Our Ref: LU/264/17/PL
Your Ref:

Town & Country Planning Act 1990 (as amended)
Town and Country Planning (Development Management Procedure) (England) Order 2015
Application for Planning Permission

Development Demolition & erection of office unit & storage area
Location Land at Fort Road Littlehampton

Block Plan. Scale 1:500

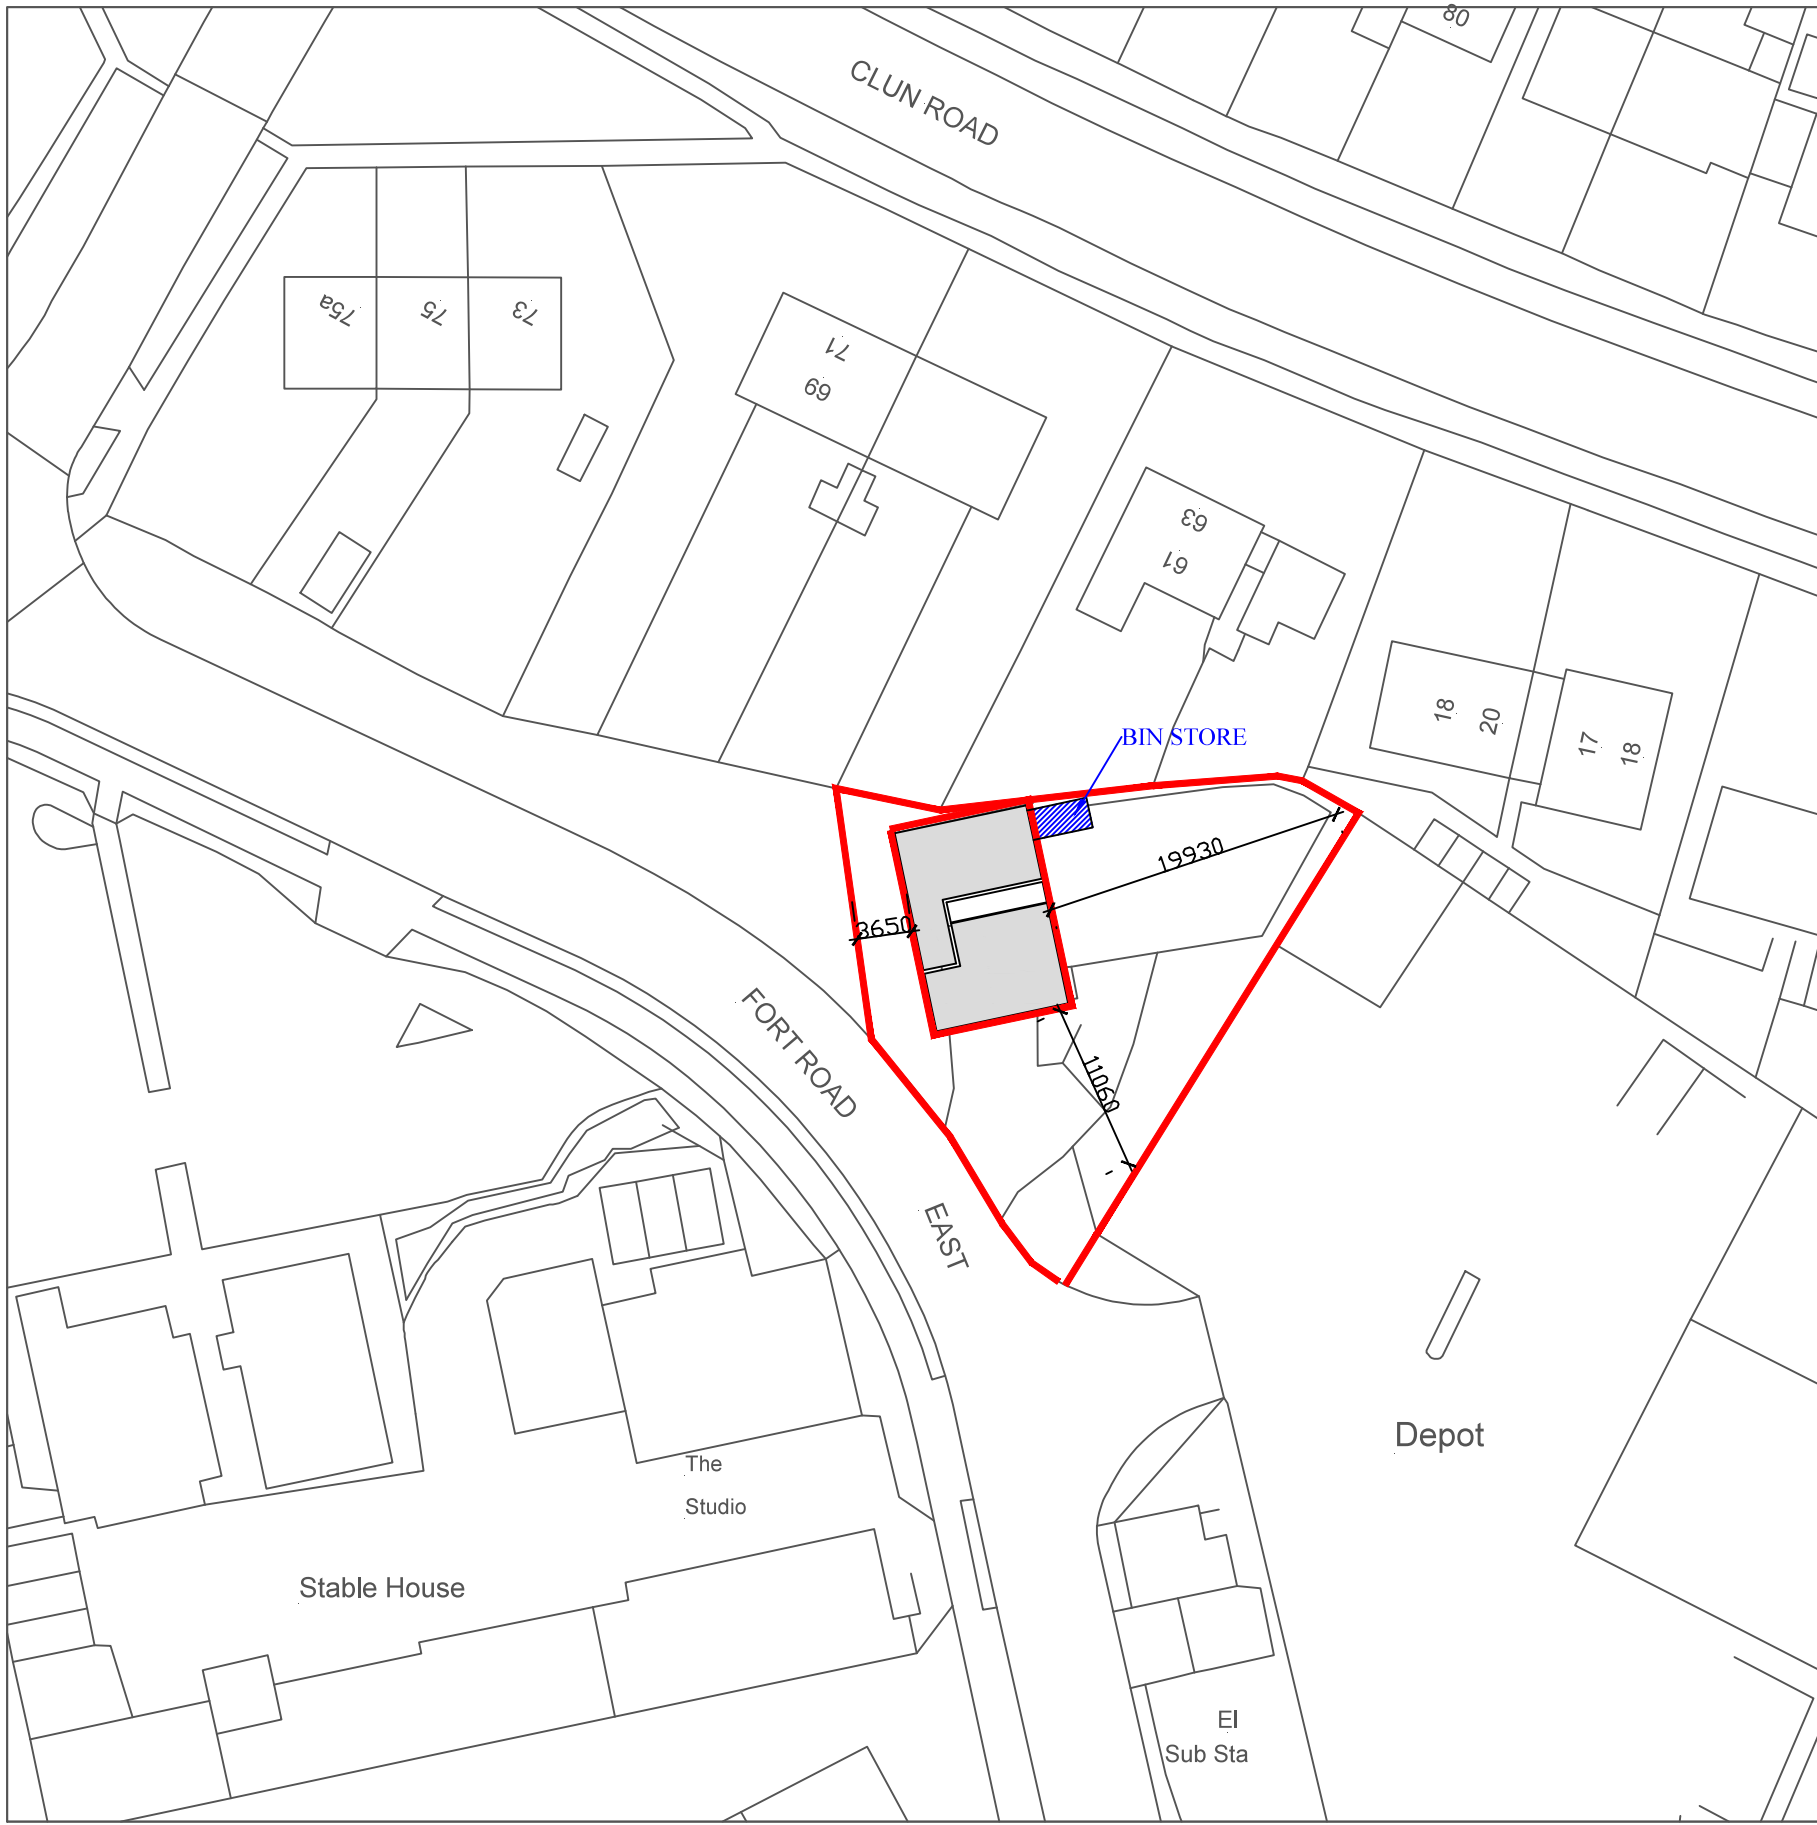
Block Plan Amend

Please submit 1 electronic or 3 paper copies of a block/site plan at a scale of 1:500 or 1:200. Further details of what must be included on the plan can be found in the National Validation Requirements. Please show the position of the bins.

Proposed Rear Elevation (North). Scale 1:100

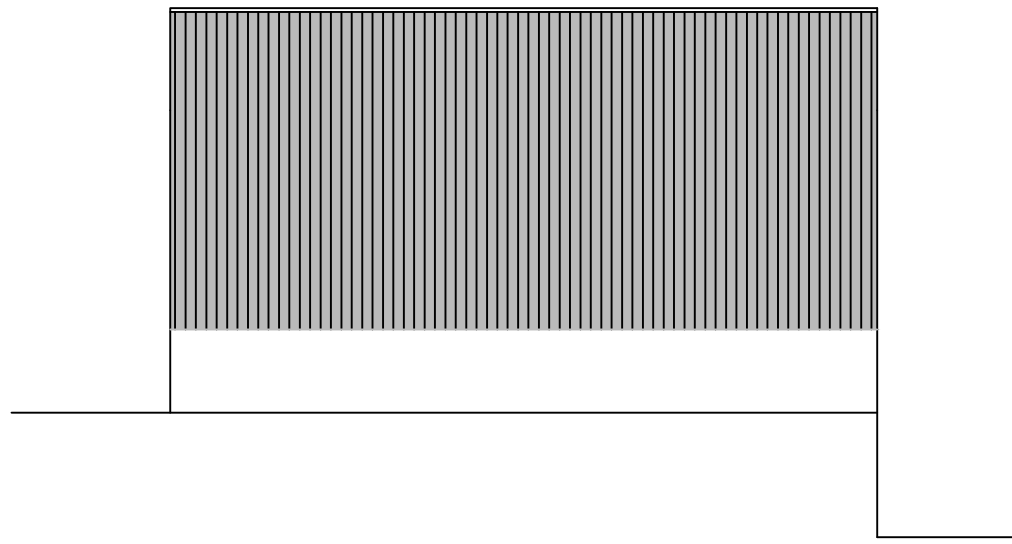
Please provide a proposed north elevation.
